Our Ref: EP/70/12/

Alterations & first floor extension, providing a reduced garden room on the ground floor, together with conversion of garage to a gym & 2 new bedrooms, study & bathroom to first floor. Removal of existing pitched roof & replace with lower mono pitched roof
Sandgate House South Strand East Preston Littlehampton

Thank you for your internet representation made on 2nd August 2012 which has been recorded as an **objection** with the comments as follows:

1207 SK26
 Sandgate House, East Preston
 Elevations As Proposed - sheet 2
 June 2012
 scale: 1:100

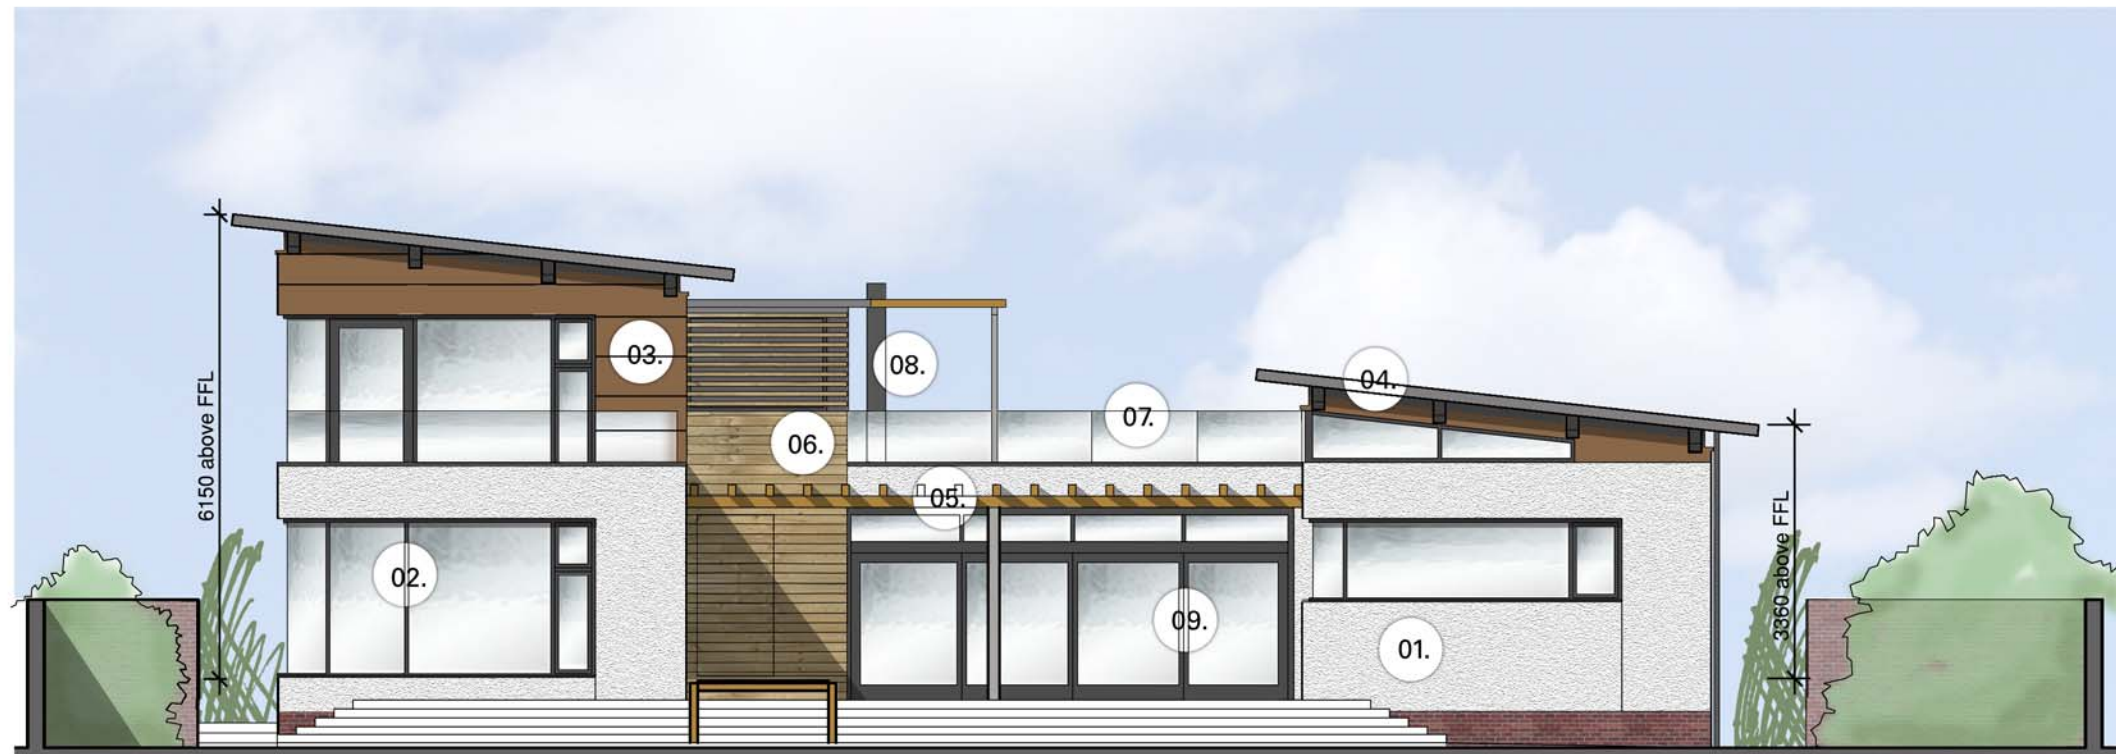
3. On the East Wing, what is the difference in height between the bottom of the pitched roof as now is, and the lower end (east side) of the proposed new roof? □

1207 SK25 A
Sandgate House, East Preston
Elevations As Proposed - sheet 1
June 2012
scale: 1:100

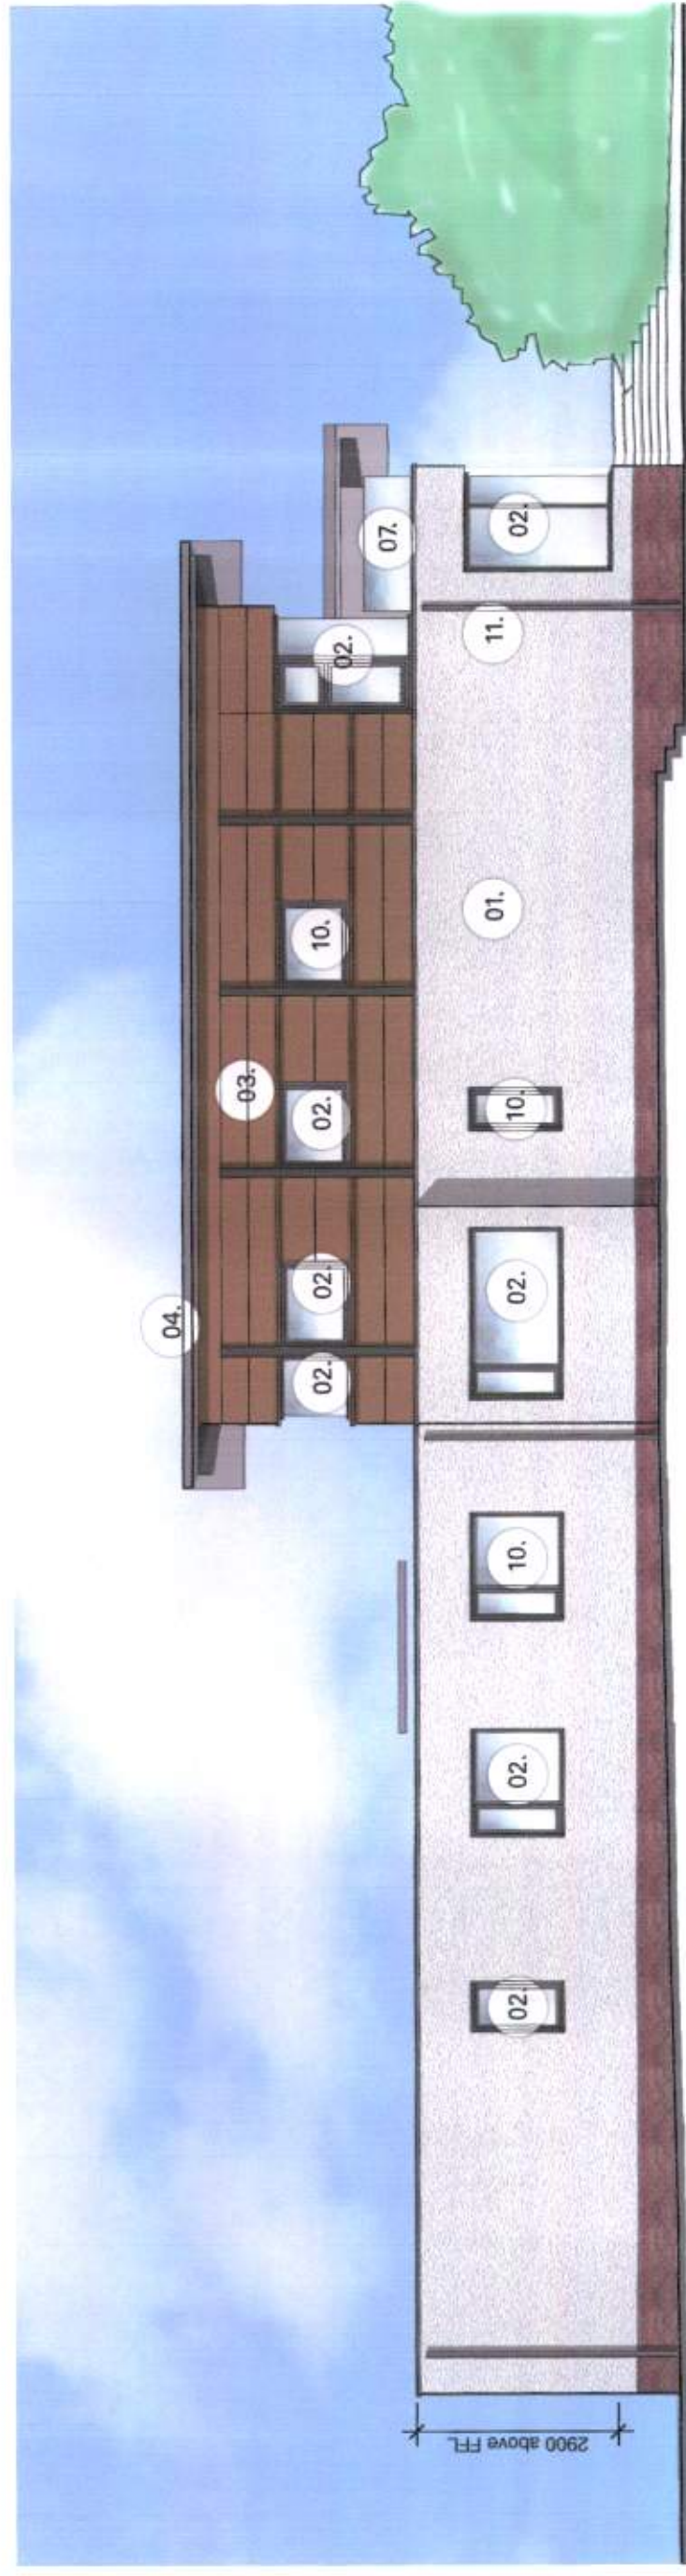
2. Please can you tell me the precise difference in height between the top of the existing pitched roof and the highest point of the proposed roof on the new 1st floor on the west wing? □

4. I also have concerns about the bay of my sitting room and my garden being overlooked with the addition of the new floor and balconies, plus the west windows of my house on my first floor. □

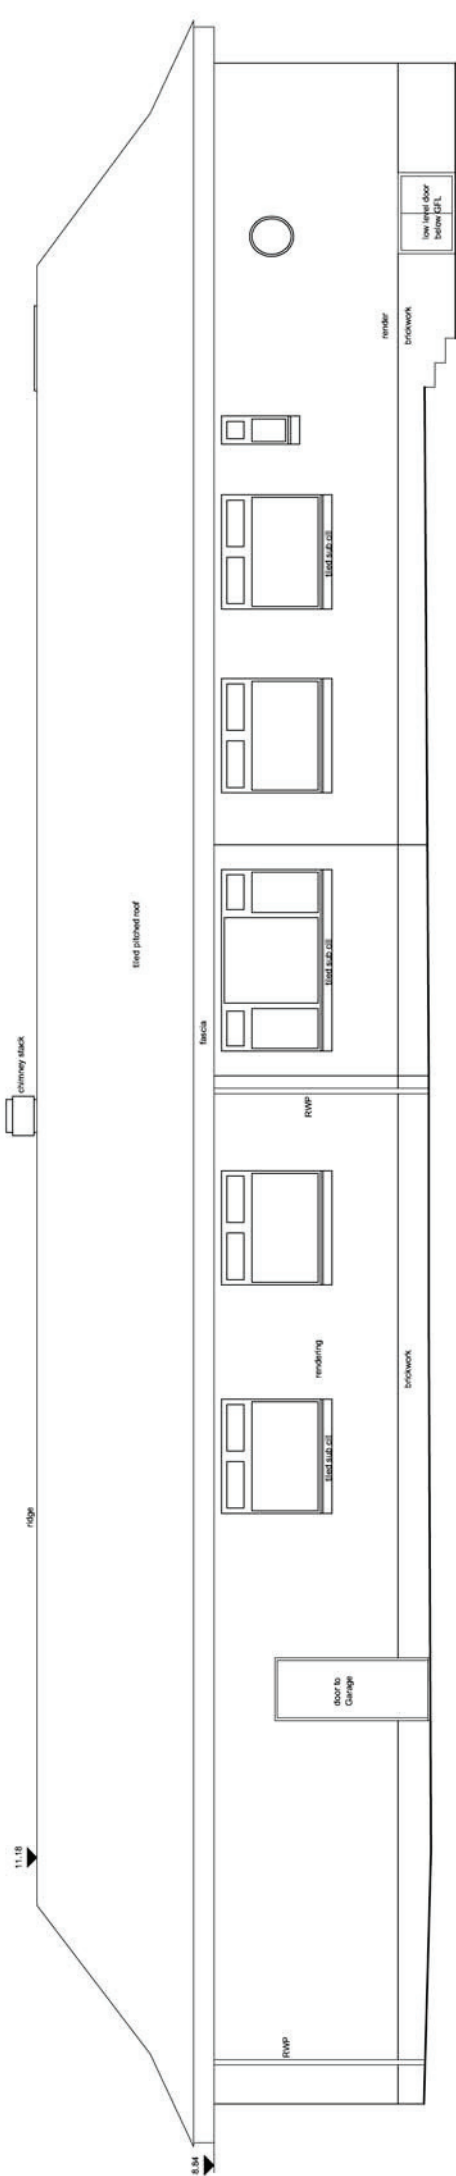
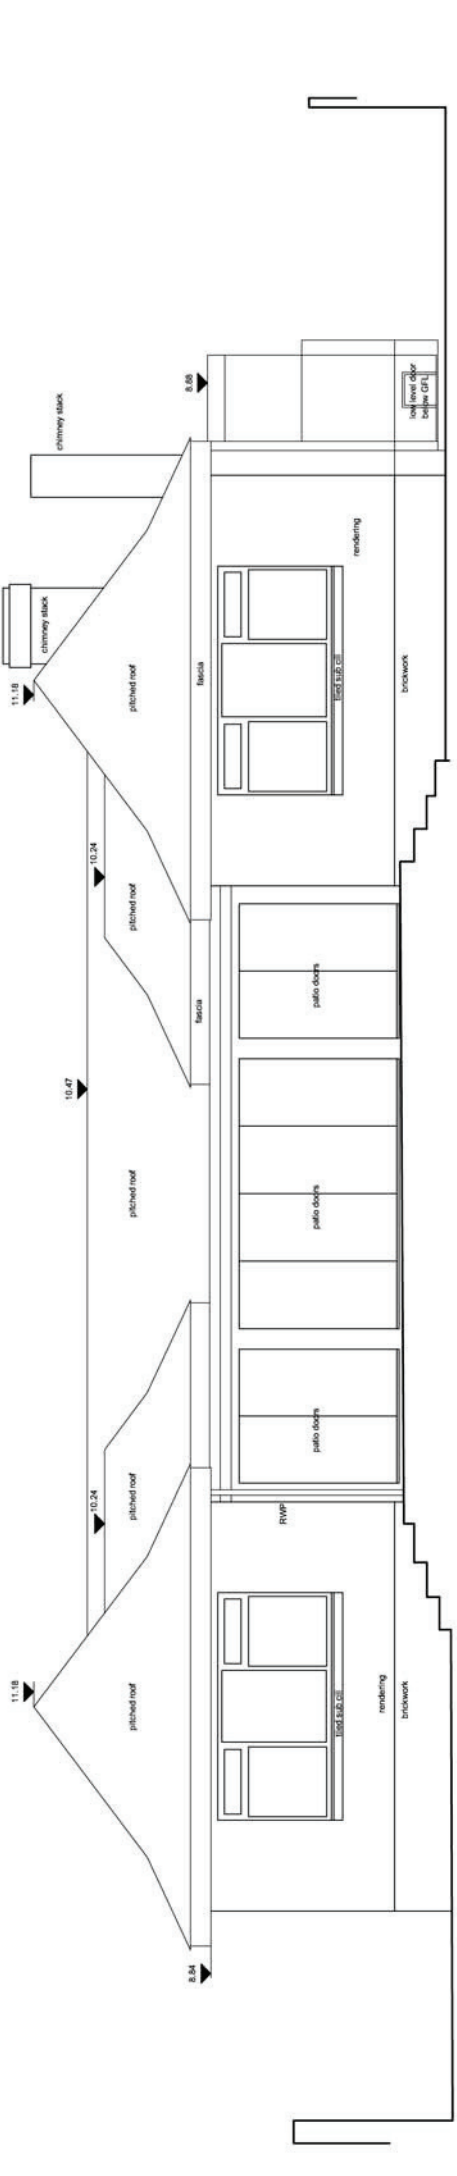
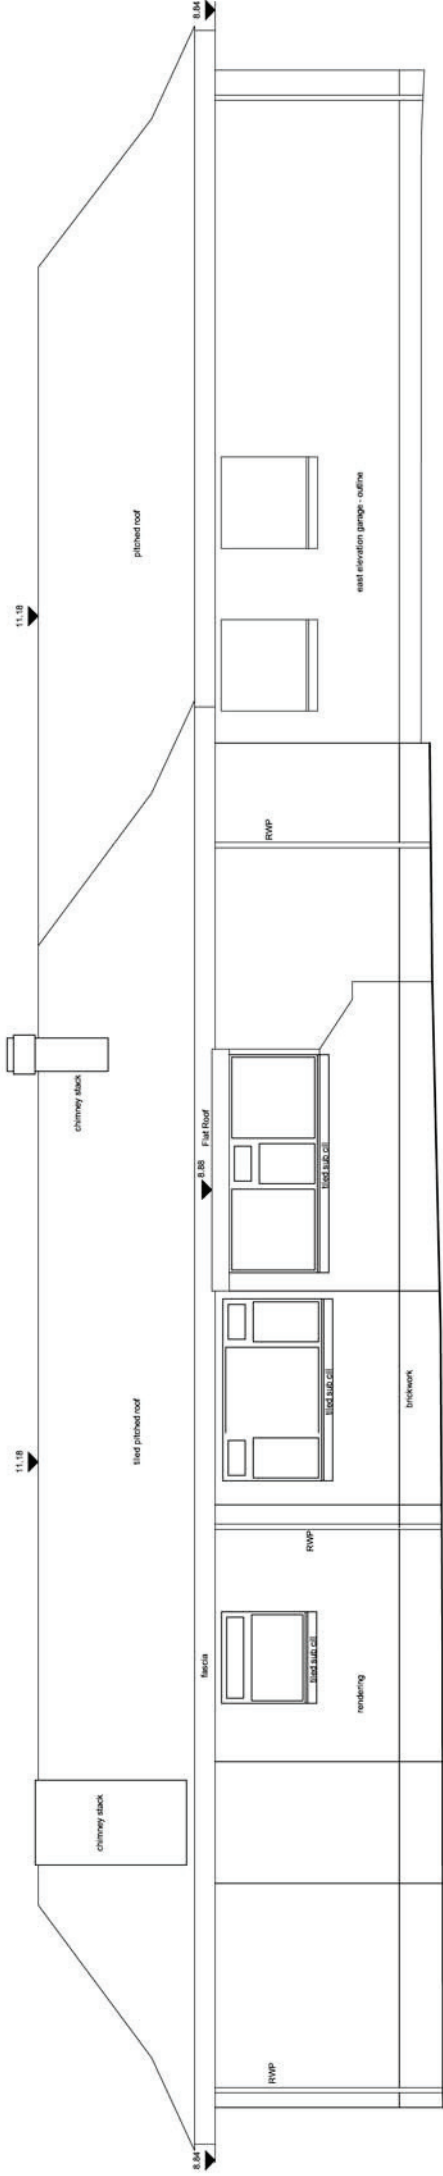
1. The measurements in SK21, the 'Elevations as Existing' are very difficult to actually see. Plus I am unclear as to what is the unit of measurement used in SK21? □
